**Consultation Response from: KC Environmental Health (Pollution & Noise Control)**

**2024/90943 217 Barnsley Road, Denby Dale, Huddersfield, HD8 8TS**

**Erection of agricultural building**

**Responding Date:**  
5<sup>th</sup> June 2024

PLAN, ELEVATIONS
& SECTION
AS PROPOSED

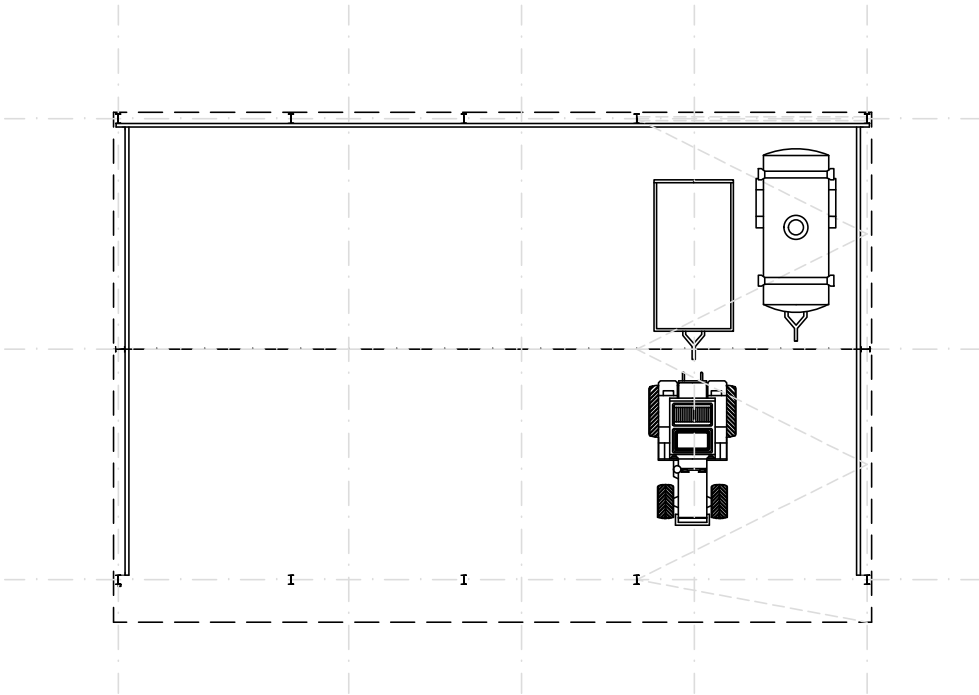
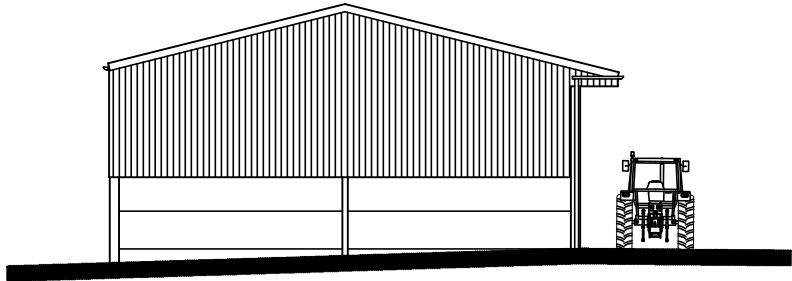
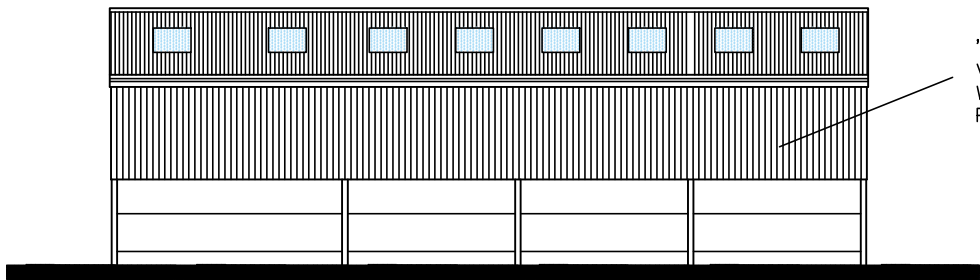
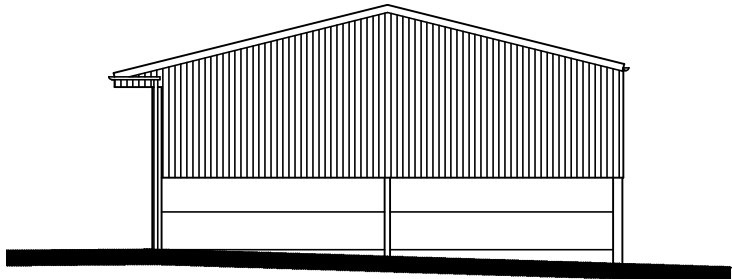
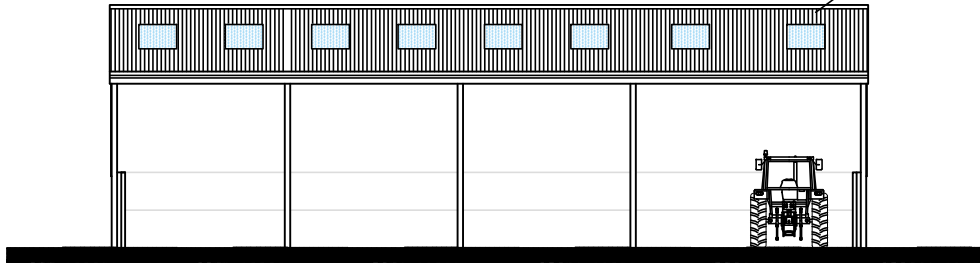
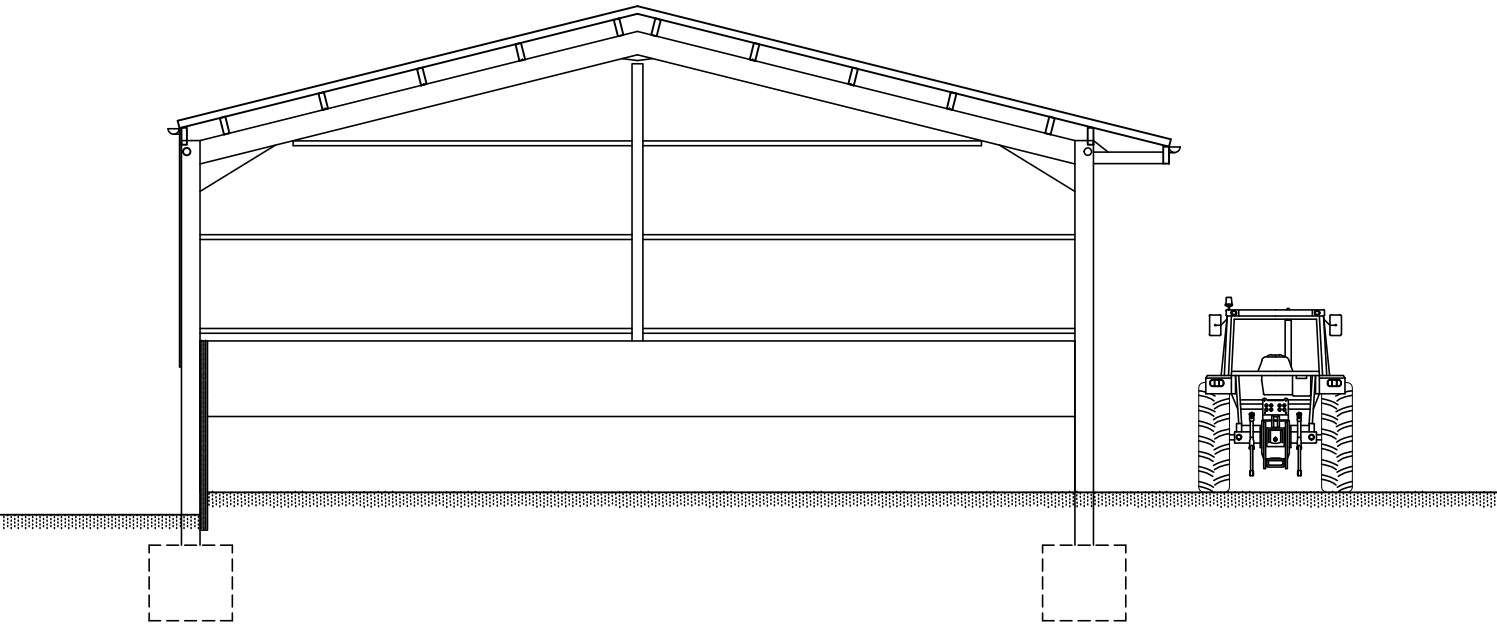
The application concerns the erection of a new agricultural building which is shown as being open to one full side and partly Yorkshire boarded to the other sides, allowing for good natural ventilation. Groundworks will be necessary; we therefore recommend a condition for unexpected contamination.

We would remind the applicant that any attempt to encapsulate or insulate the building in future would compromise the natural ventilation and may put receptors within the building at risk.
